| Application number: 2020/94055   |                                                                    |
| What is the application for?:    | Erection of 7 dwellings and associated access works                |
| Address of the site or building: | Land opposite, 4, Coalpit Lane, Upper Denby, Huddersfield, HD8 8UF |

DRAWING TITLE
HOUSE TYPE DRAWING

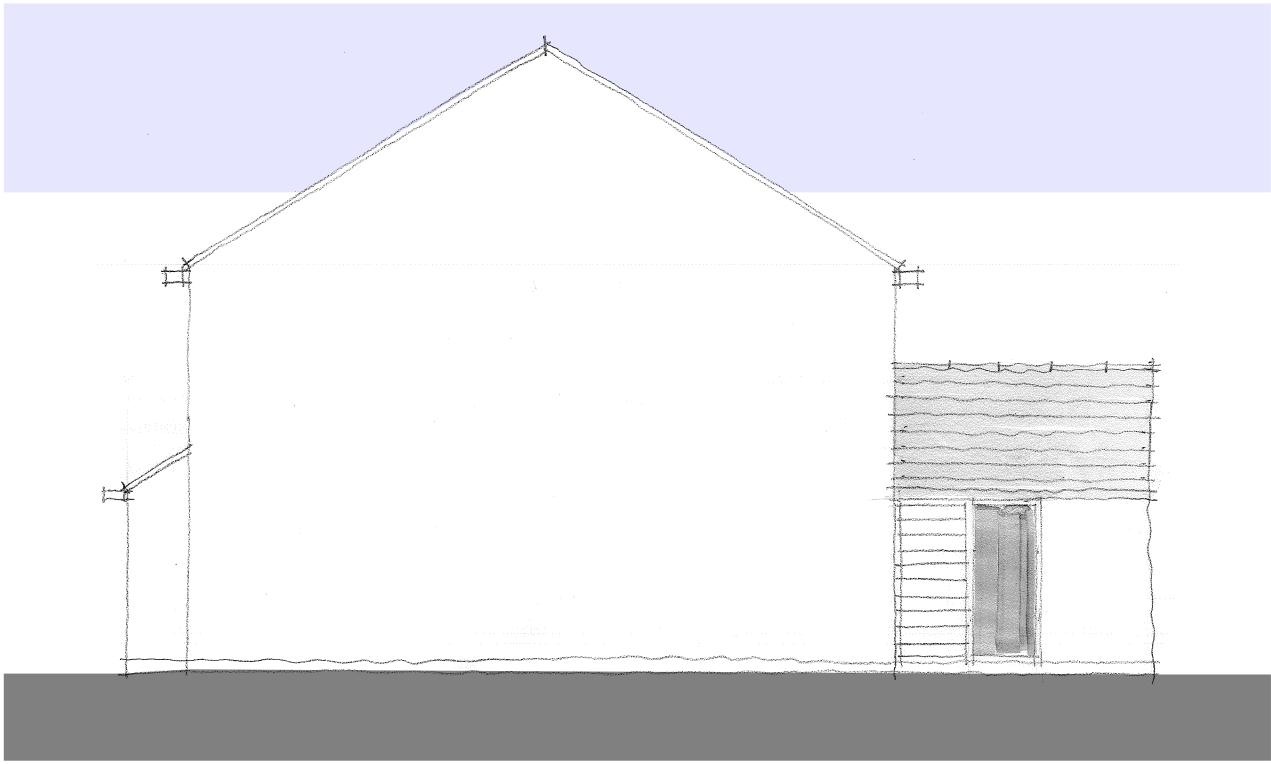
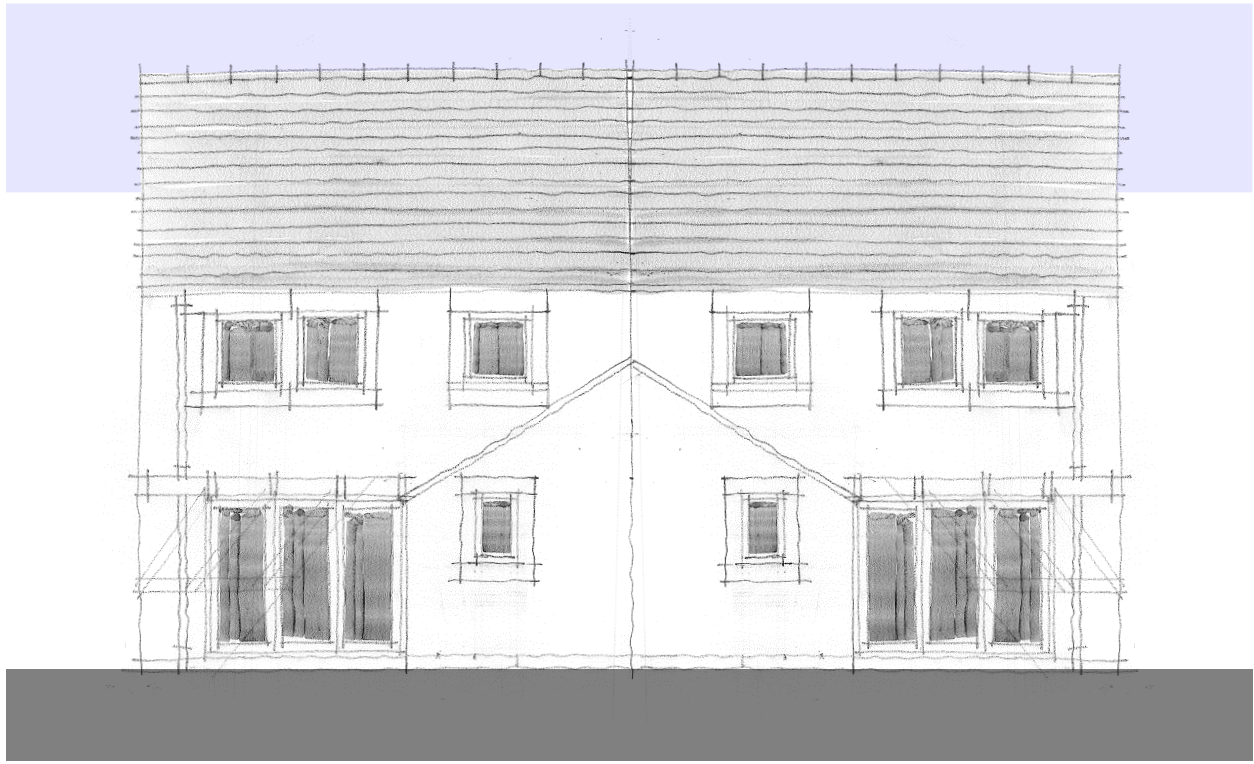
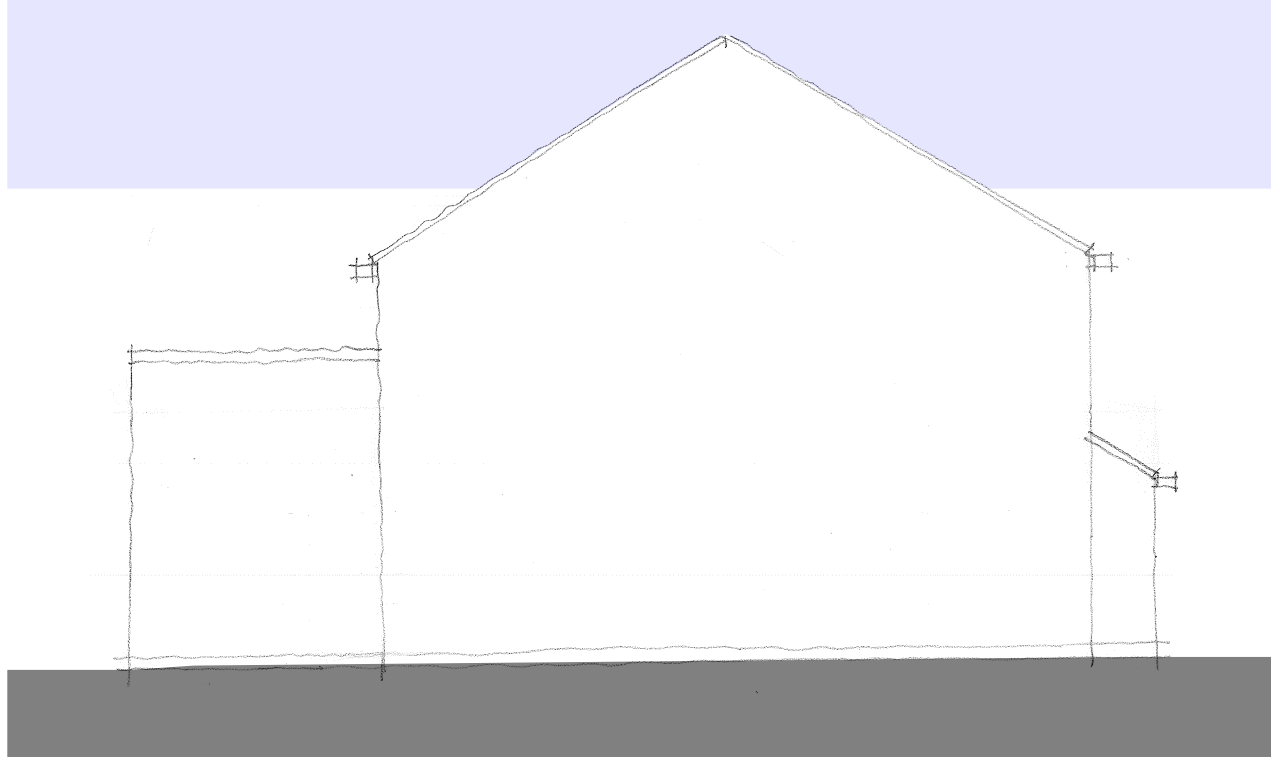
| <p>I wish to object most strongly to the above application on the following grounds: The materials to be used include PVC windows, composite doors and concrete roofing tiles. As the site is adjacent to the Conservation area, and other stone built properties, it would be more appropriate to insist on timber windows, doors and natural stone slates. There are serious problems already in this area regarding effluent removal, and another seven houses will certainly exacerbate this issue. Whilst this application is for seven dwellings, the letter supporting this, states it is for 5 detached houses. Which is it?</p> <p>Another anomaly is the entrance to the site – on one plan (outlined in red), it shows what could be a proposed entrance from Greenfield Close, whilst the application states the access is via Coal Pit Lane. On the plan showing the seven houses, it doesn't even show an entrance/exit - very confusing! An entrance from Coal Pit Lane would be totally inappropriate, as mentioned in previous attempts to build on this site, as is narrow, on a blind corner, and used by children walking to school.</p> |     |
